Planning reference: FG/42/19/HH
22 Singleton Crescent, Ferring BN12 5DG

Single storey front extension, side extension, conversion of garage to habitable use and conversion of roof space to habitable use to include a rear dormer and 3 front roof lights.

Comments on subsequent correspondence between Atterbury Moore Associates and Planning Department at Arun District Council

AR-138-10

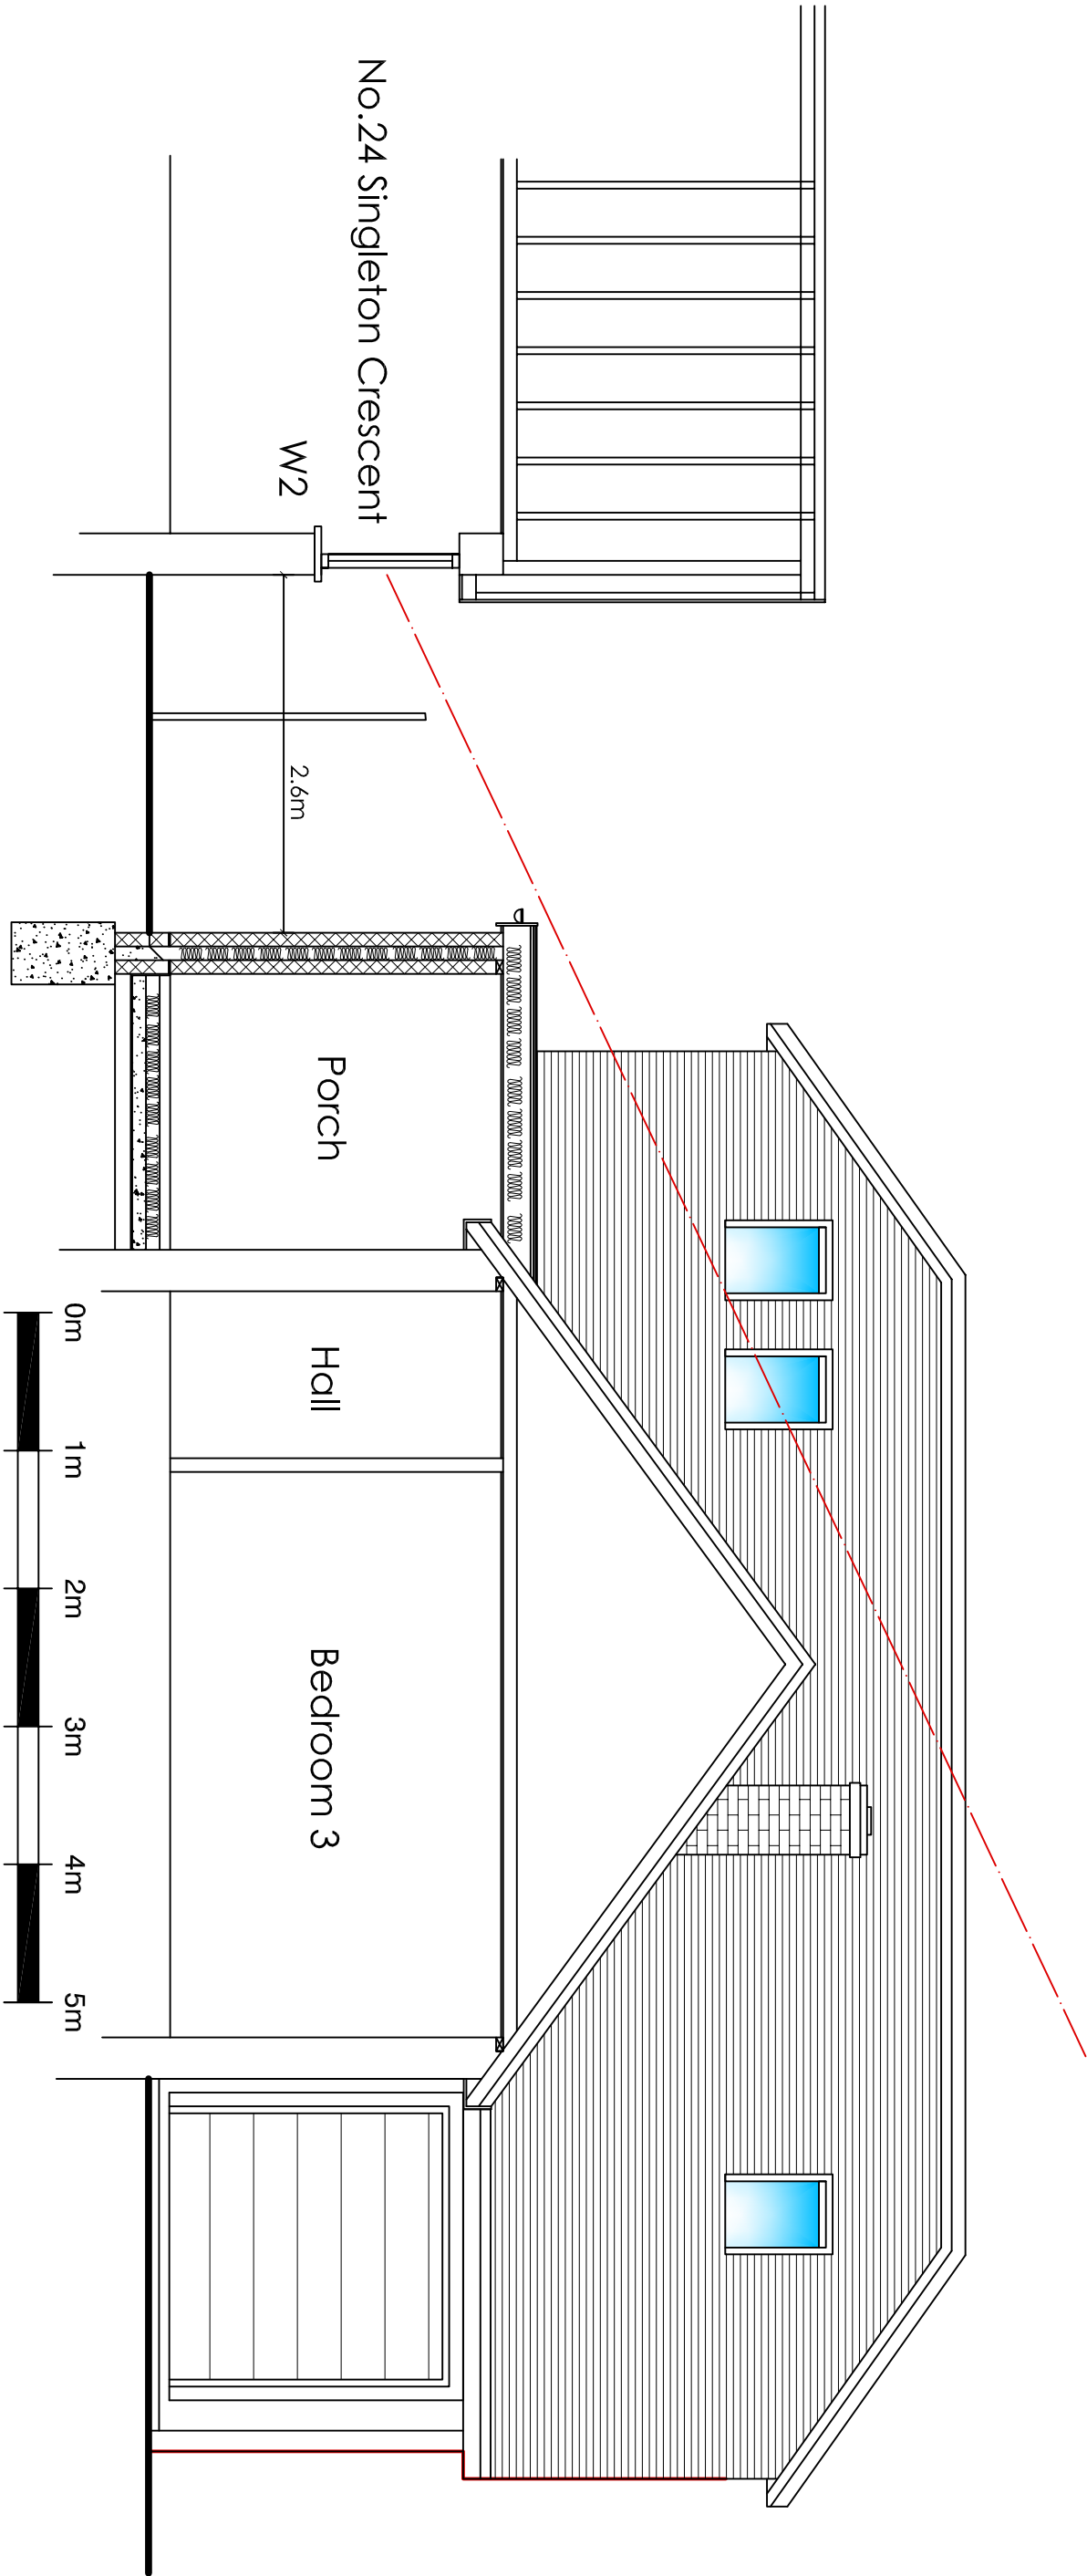
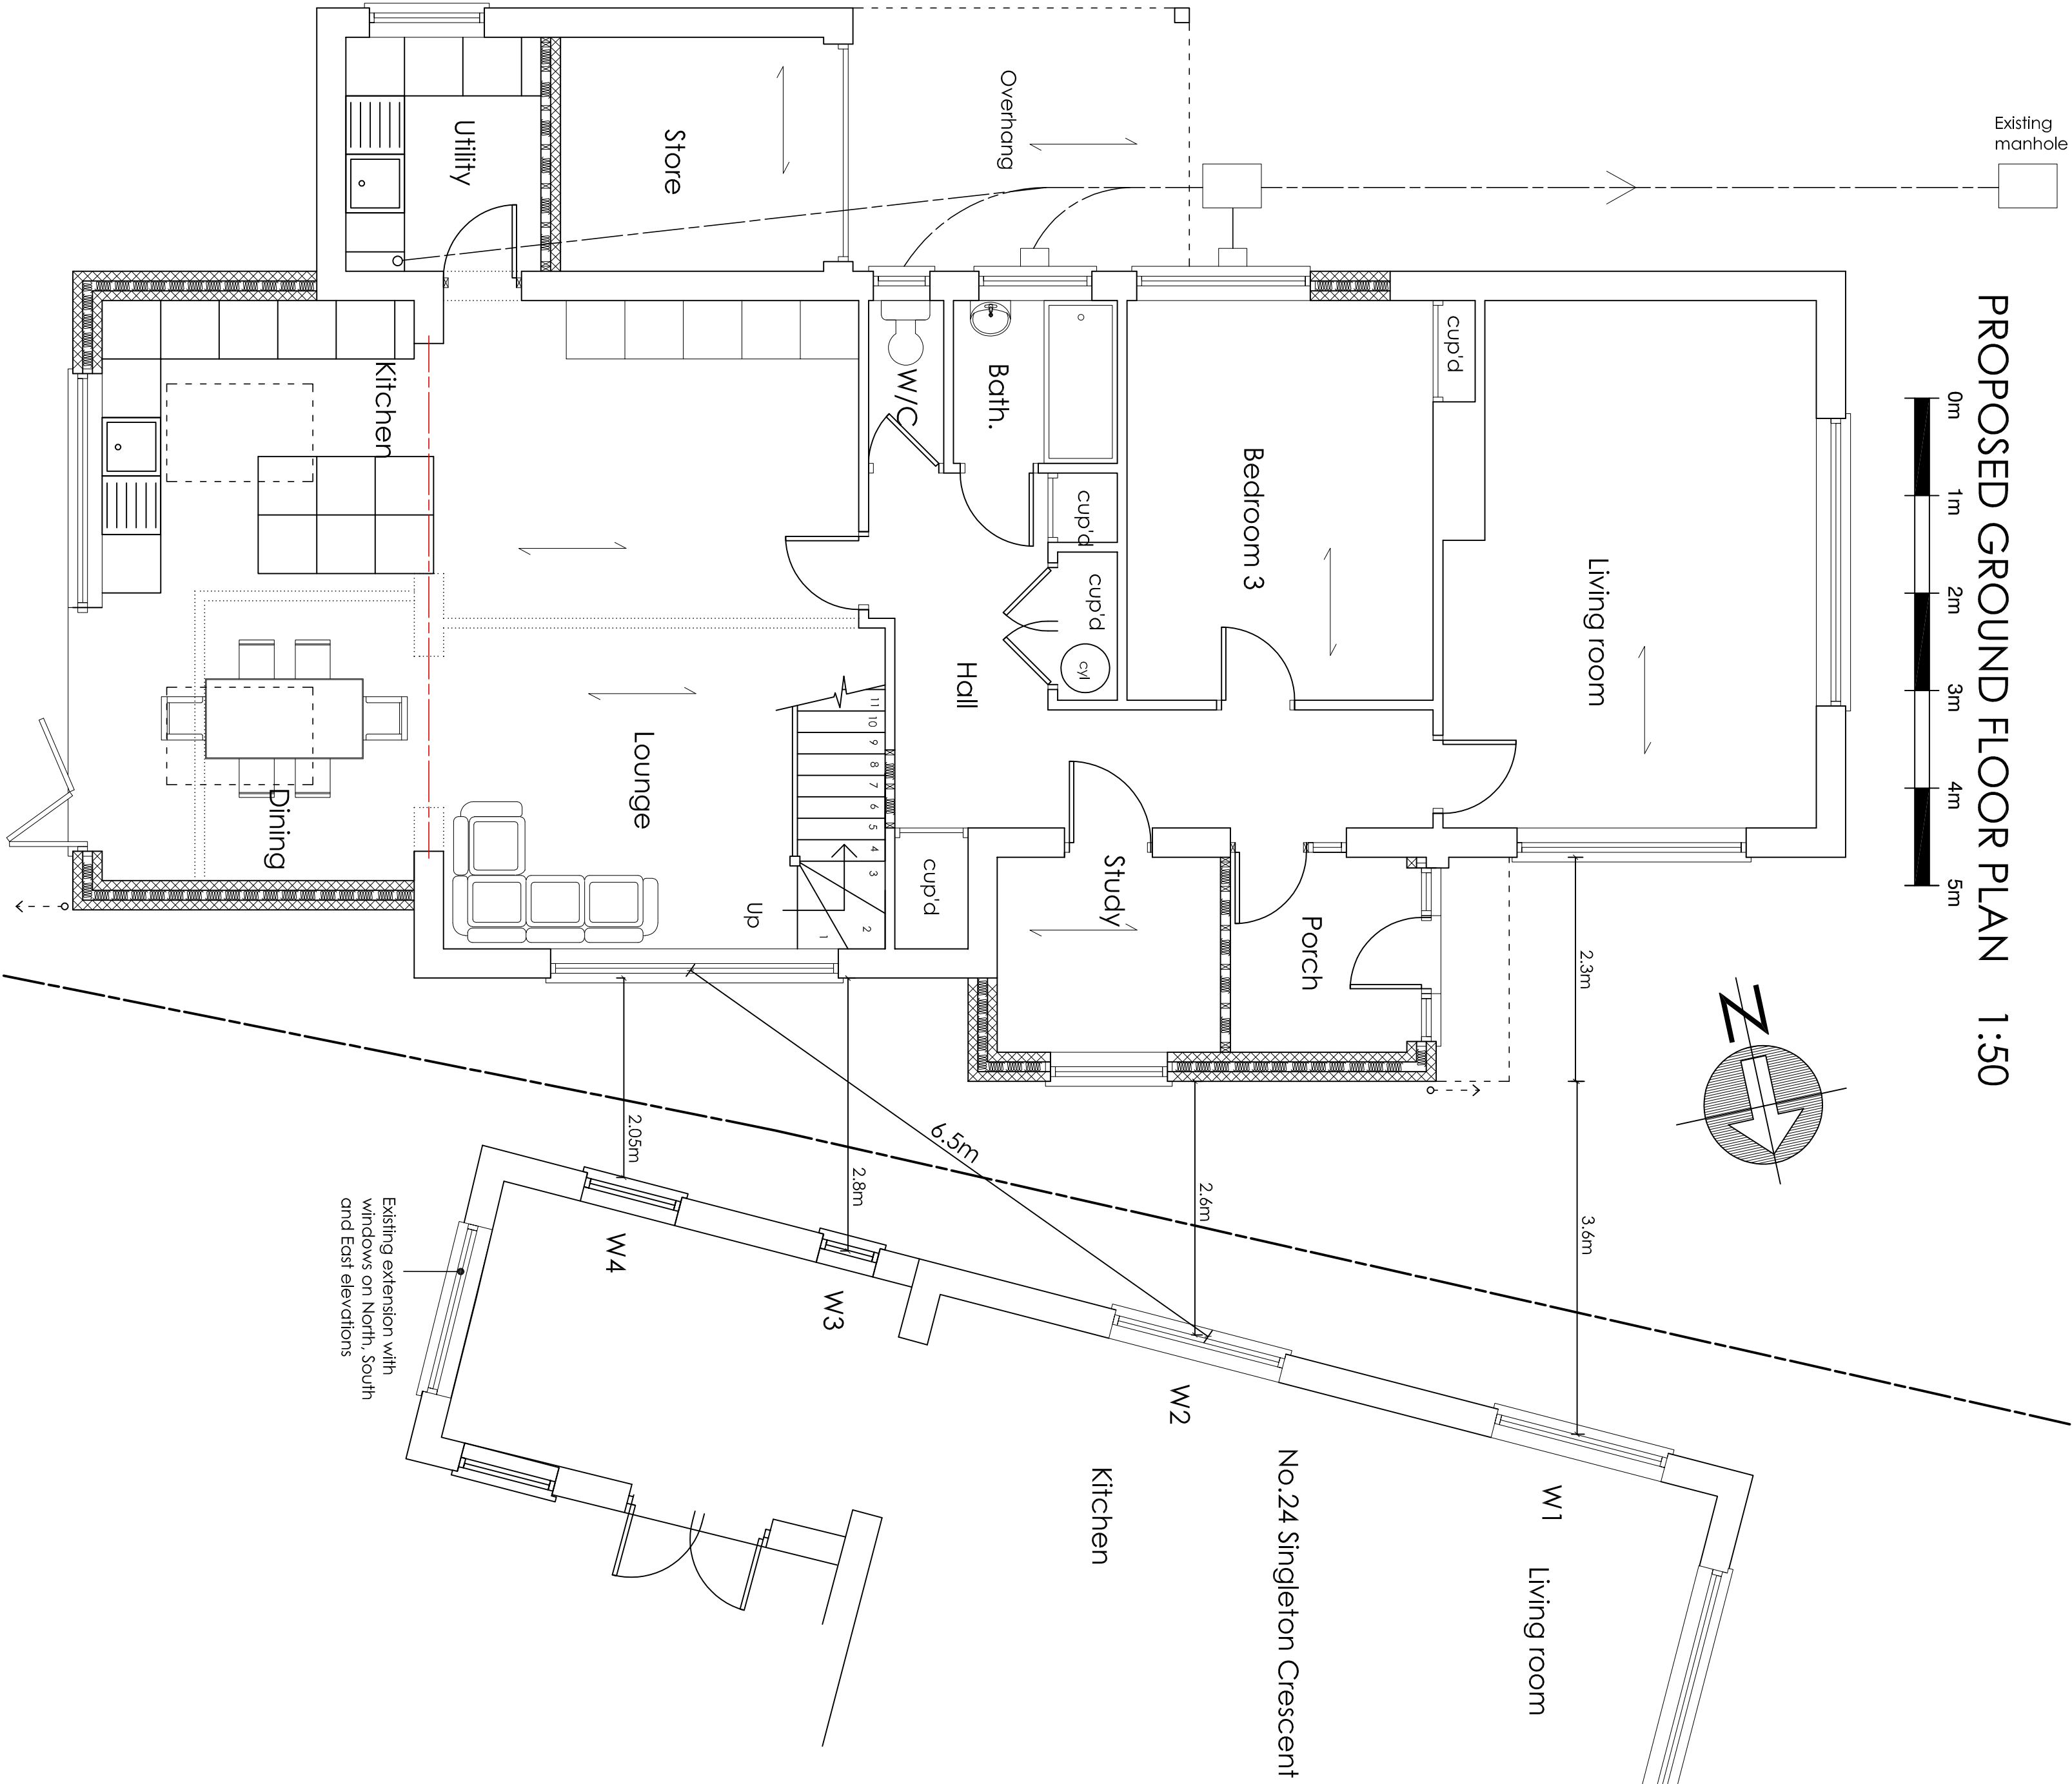
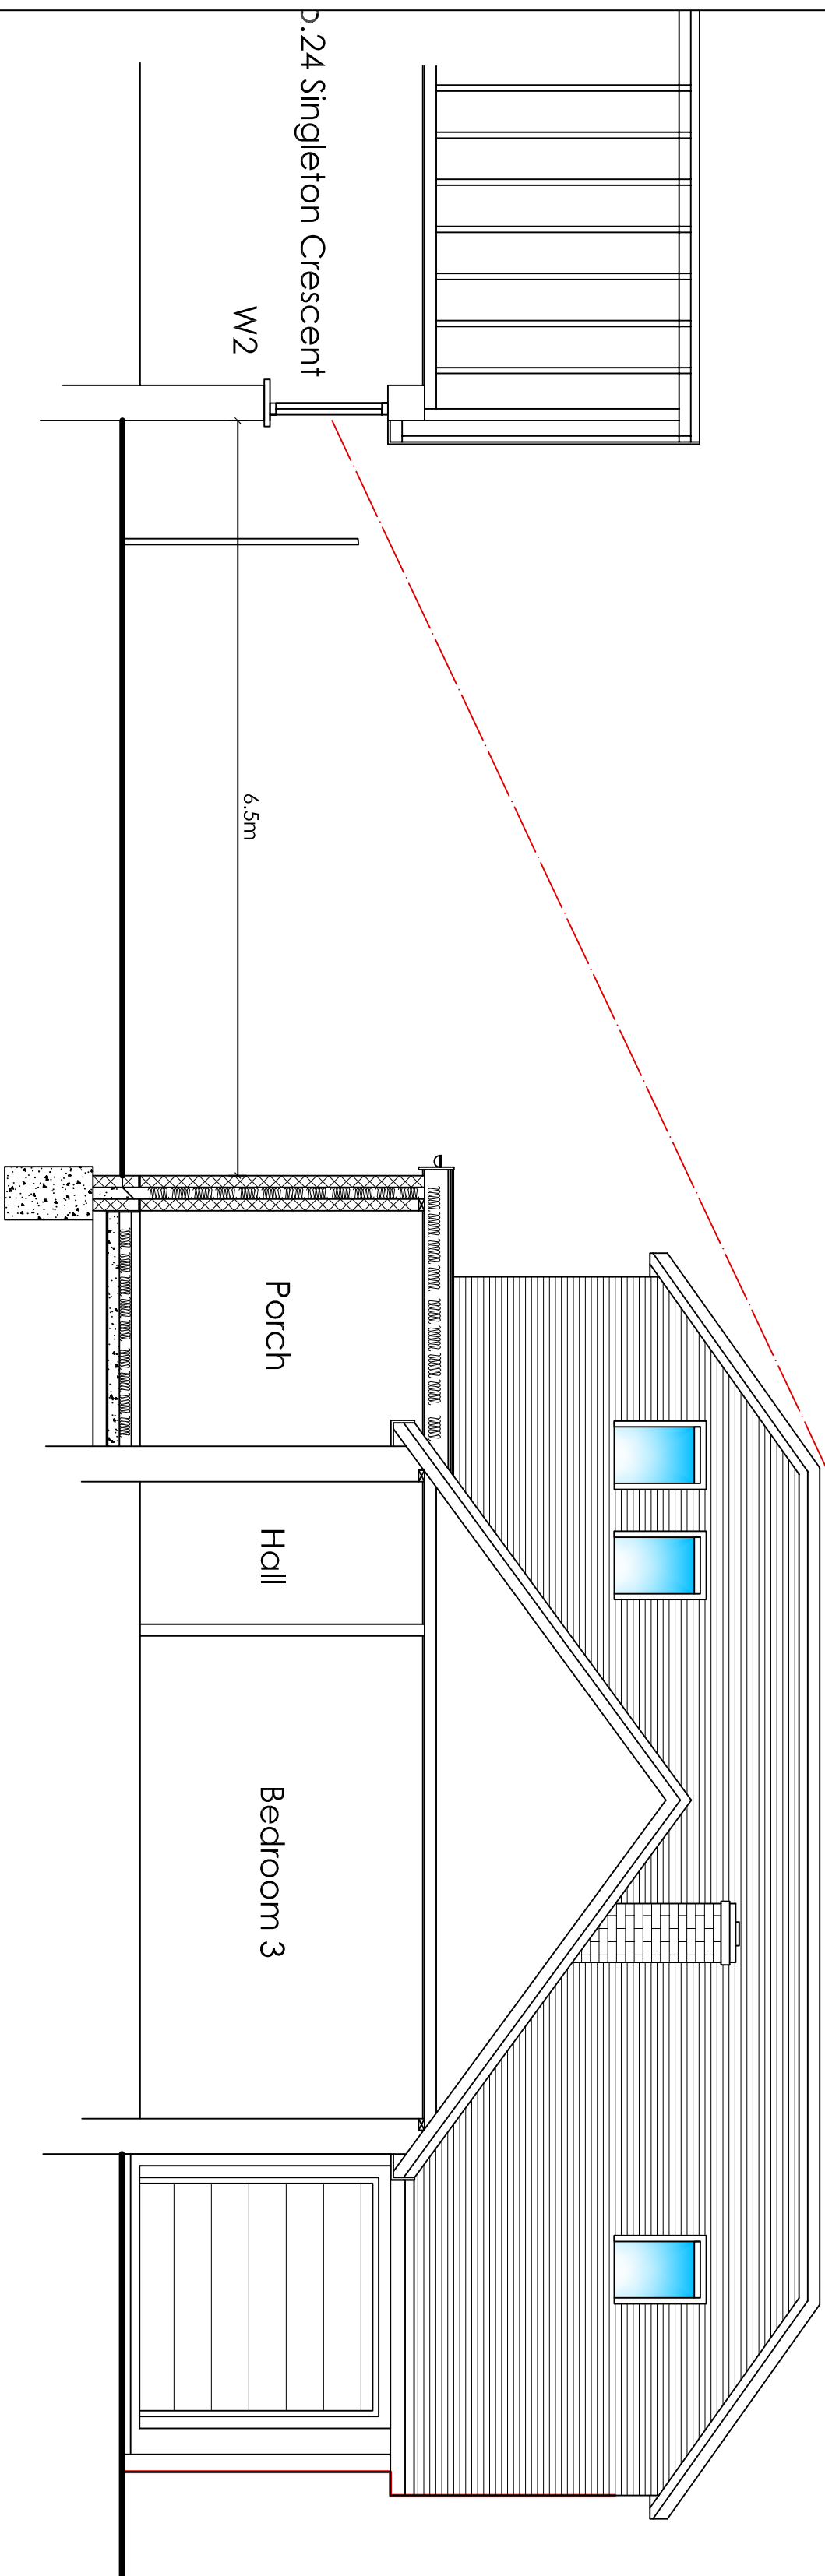
2. Regarding the request by yourselves for a 45 & 25 degree angle light test from a lay persons point of view it would appear that Mr Moore has failed to provided the information you required in that he has given dimensions and angles from W2 rather than W3 or 4 as per your request.
